4 October 2017

File No: SSD 6513 MOD 3
Our Ref: R/2014/14/E

RE: BUILDING R1, BARANGAROO SOUTH – SSD 6513 MOD 3

Solotel – Barangaroo House
External signage

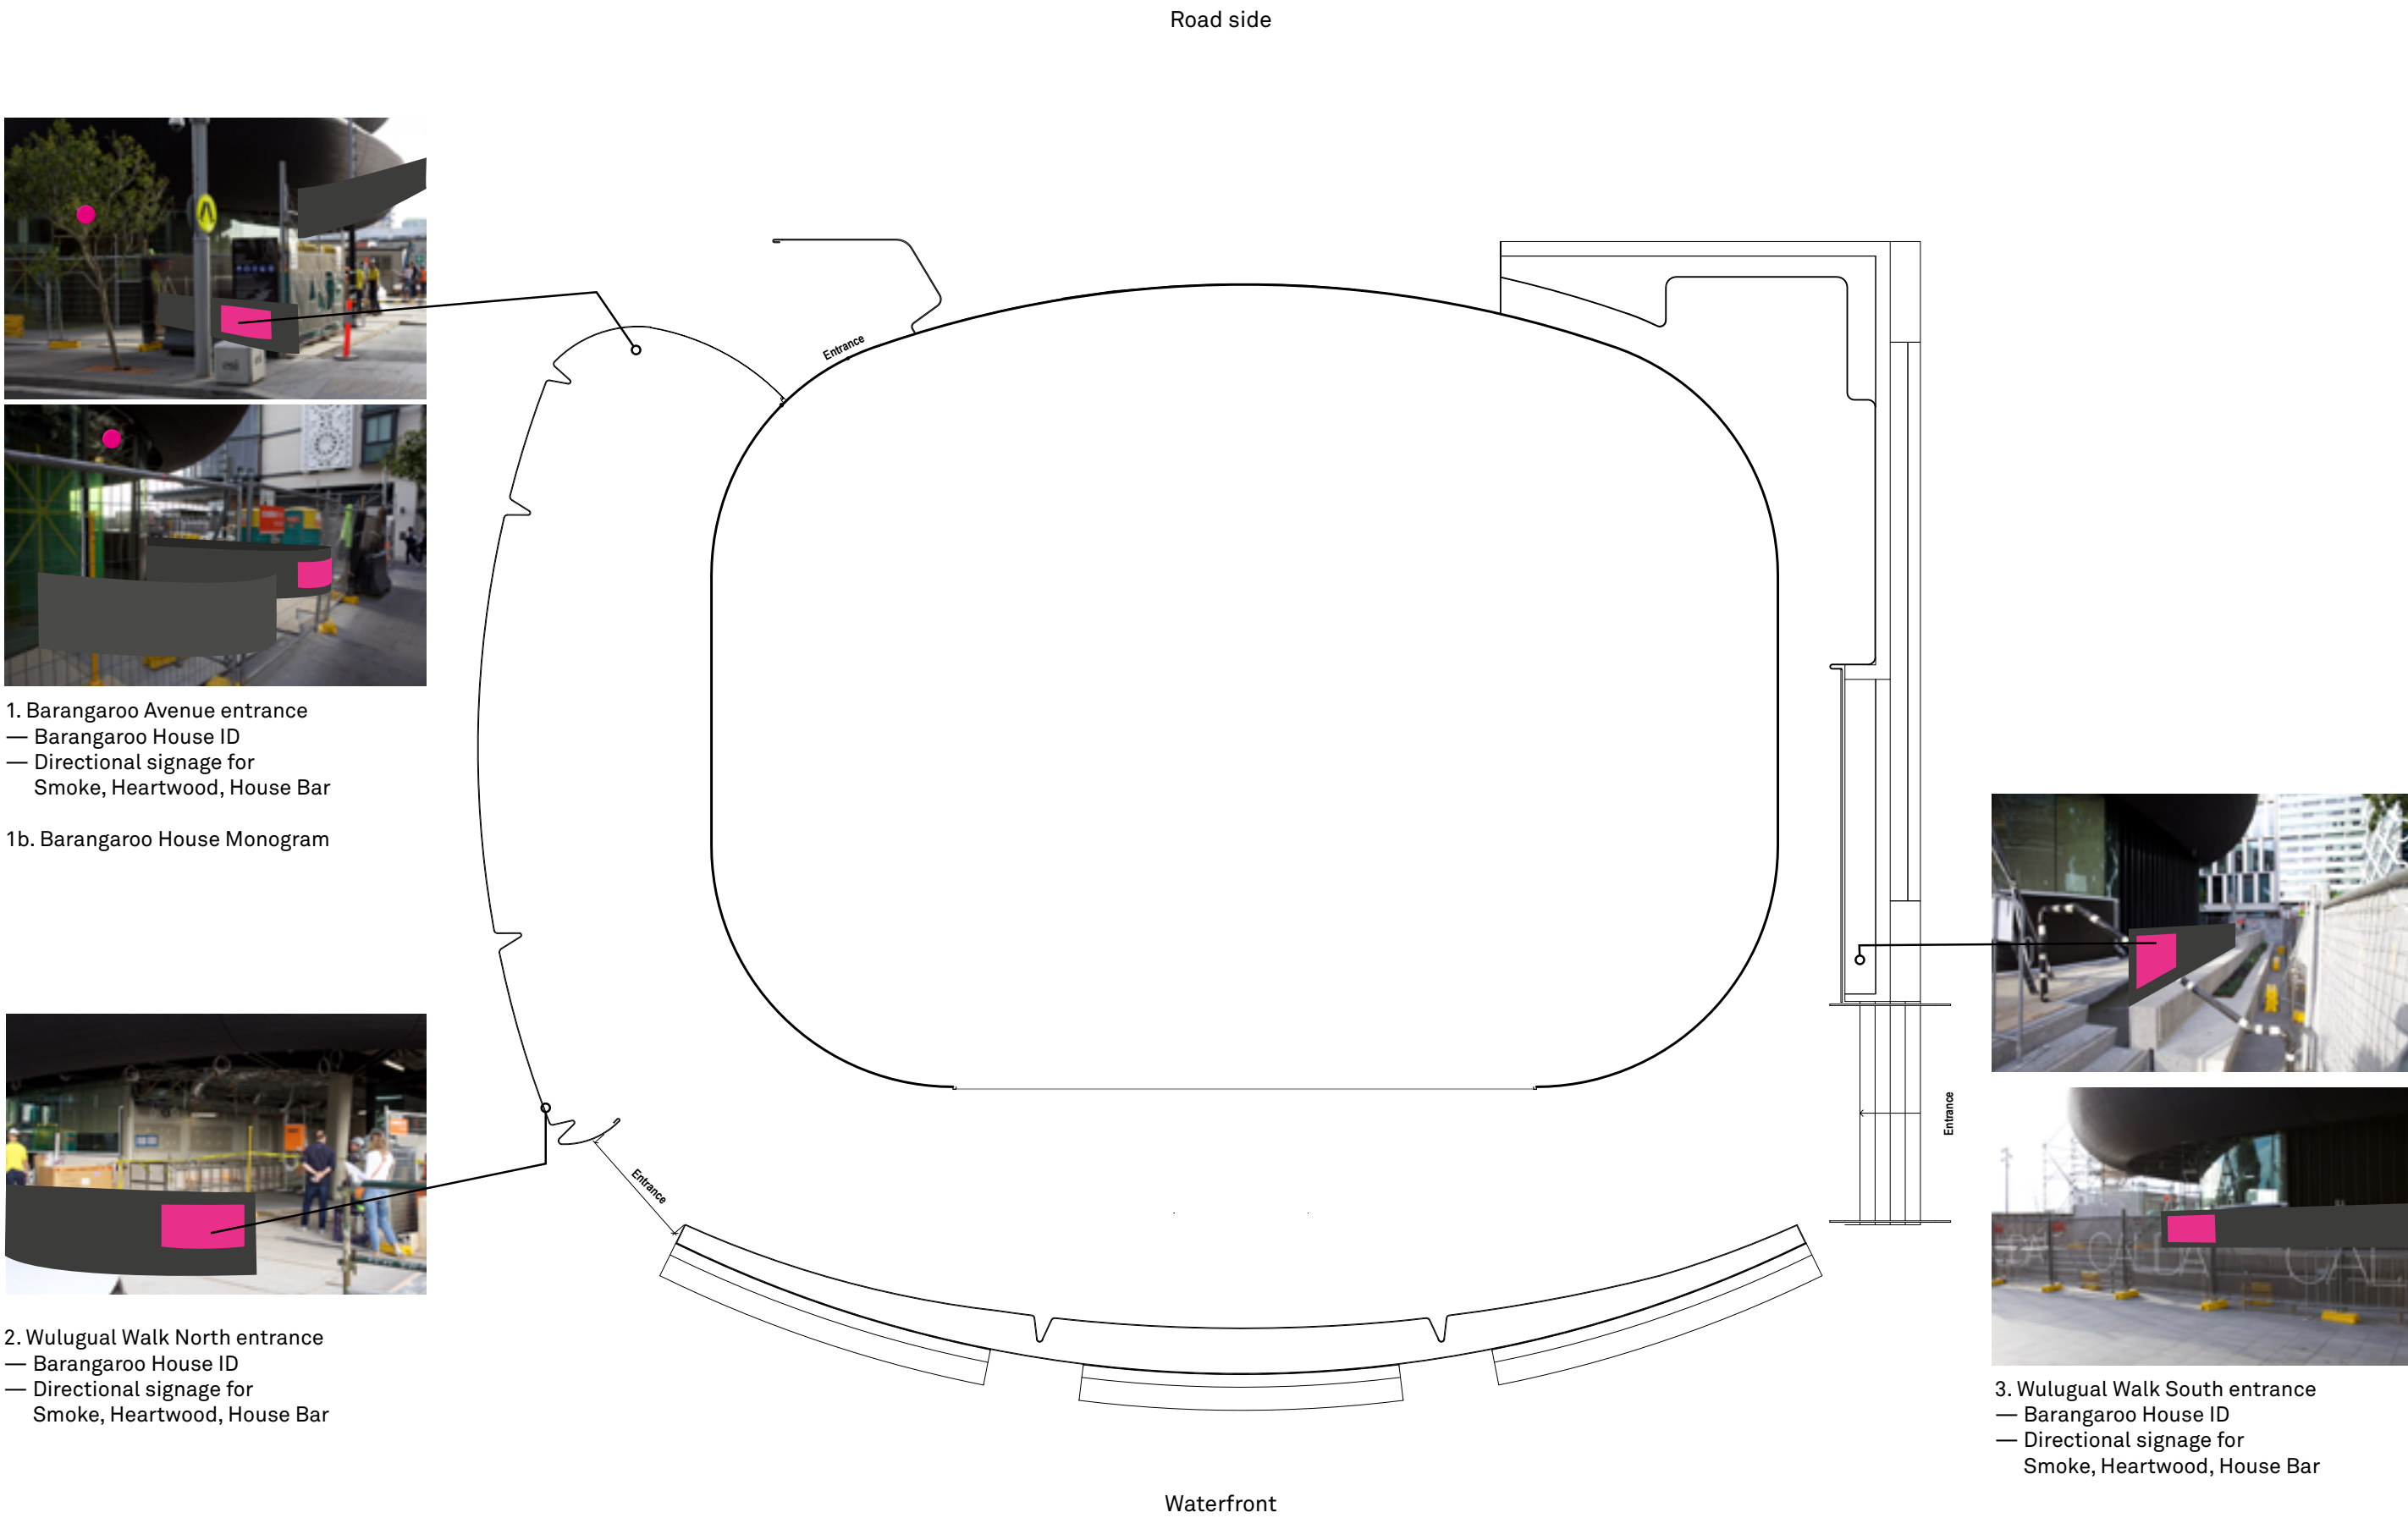
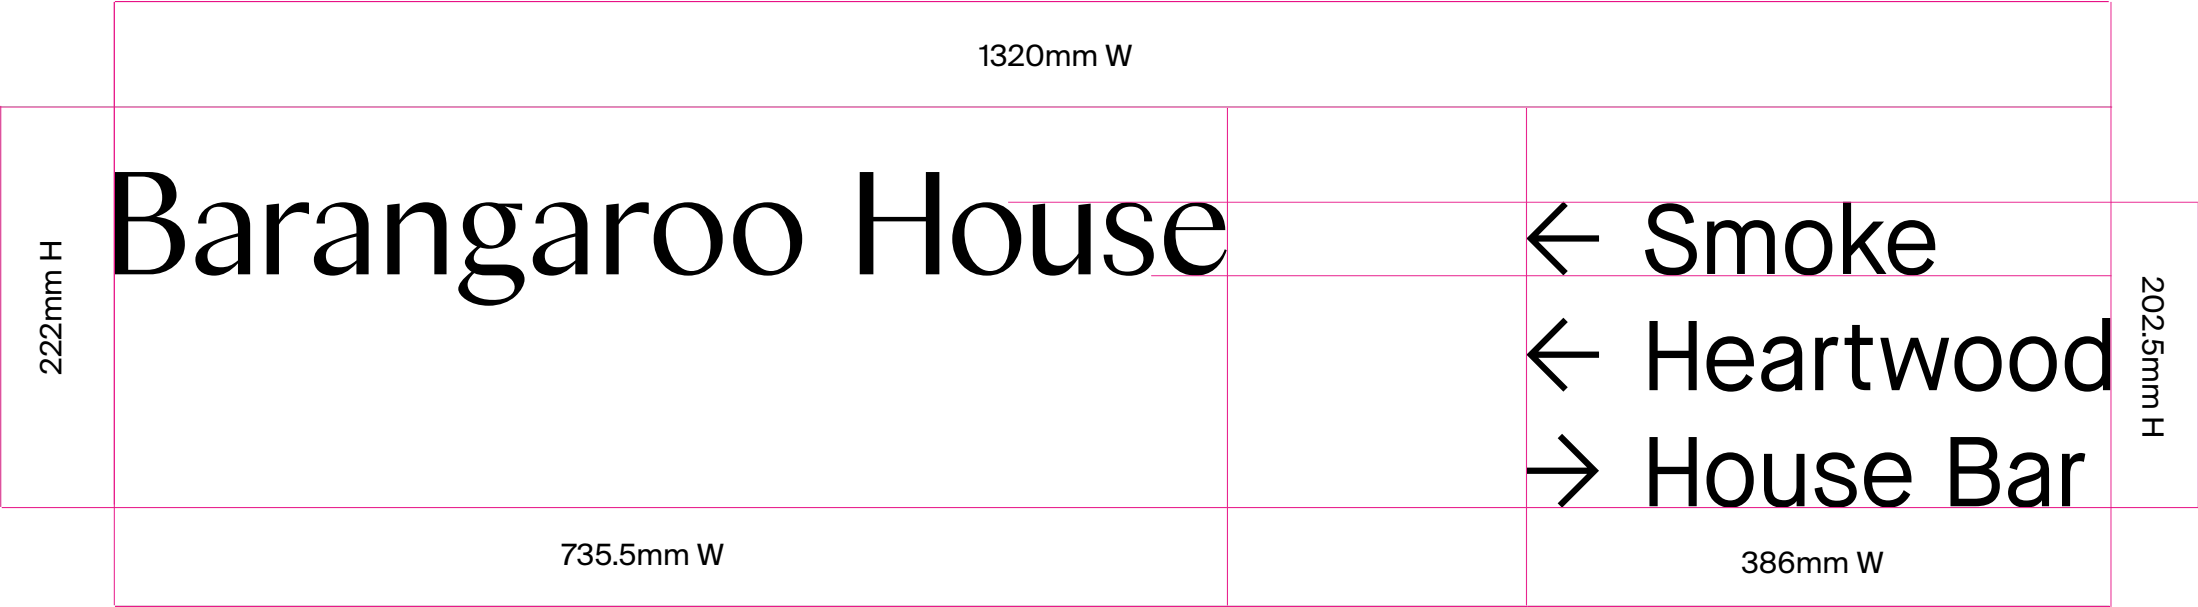
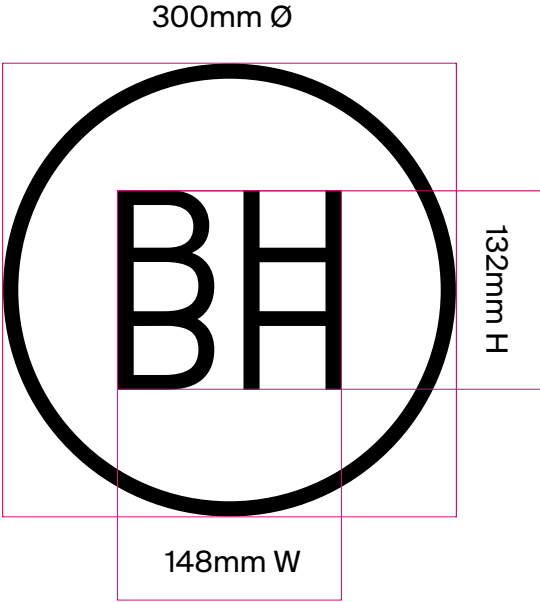
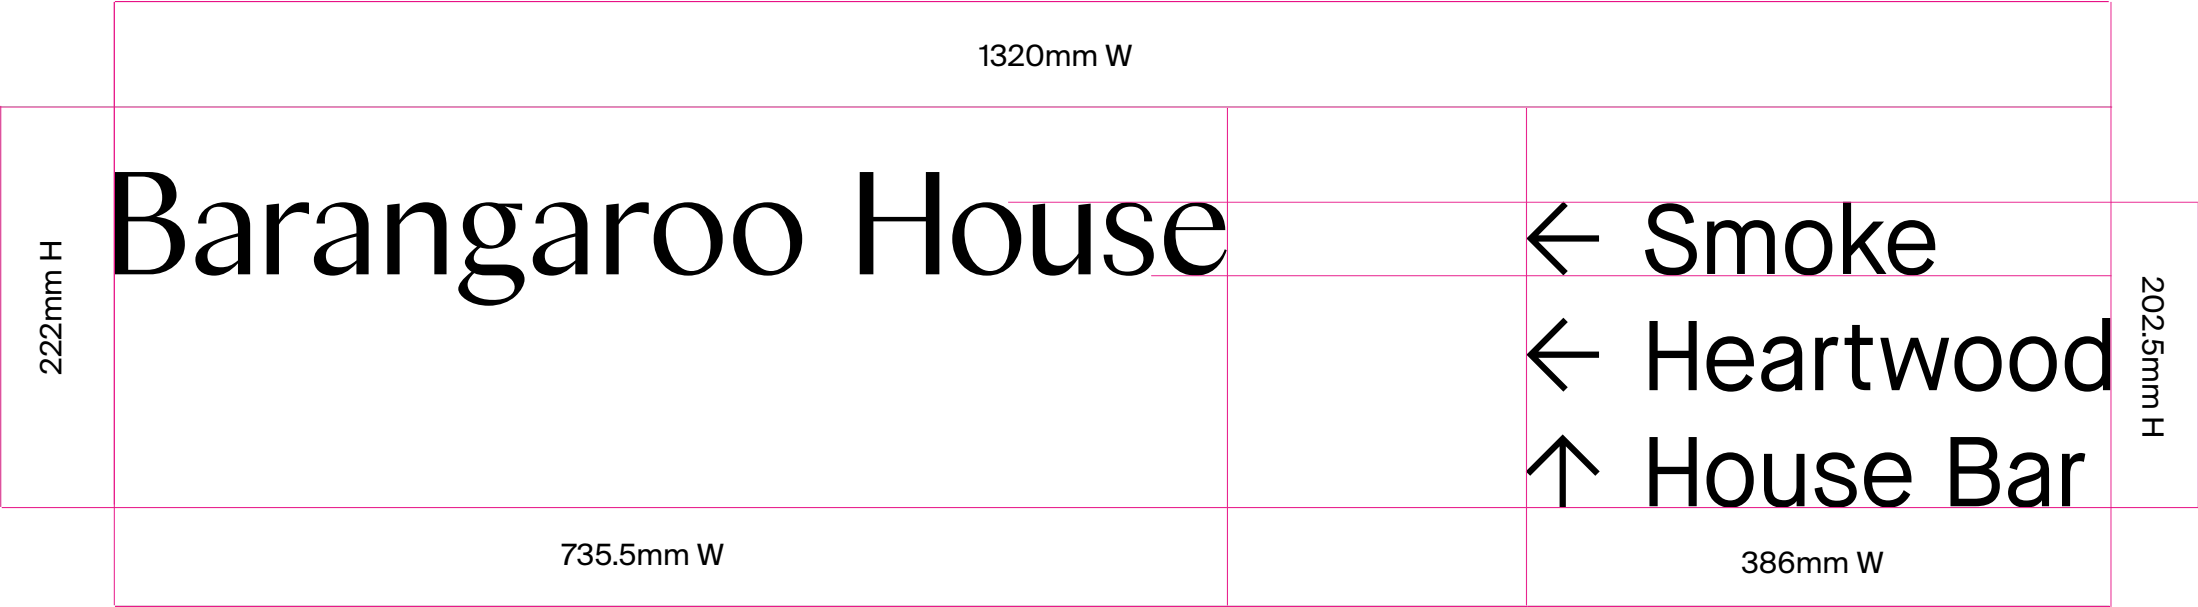
There is insufficient information to provide comments on these element of the proposal. It is also unclear how the proposed ‘signage zones’ integrate into the structures. It is recommended that further details, maybe at a scale of at least 1:20, be provided for assessment.
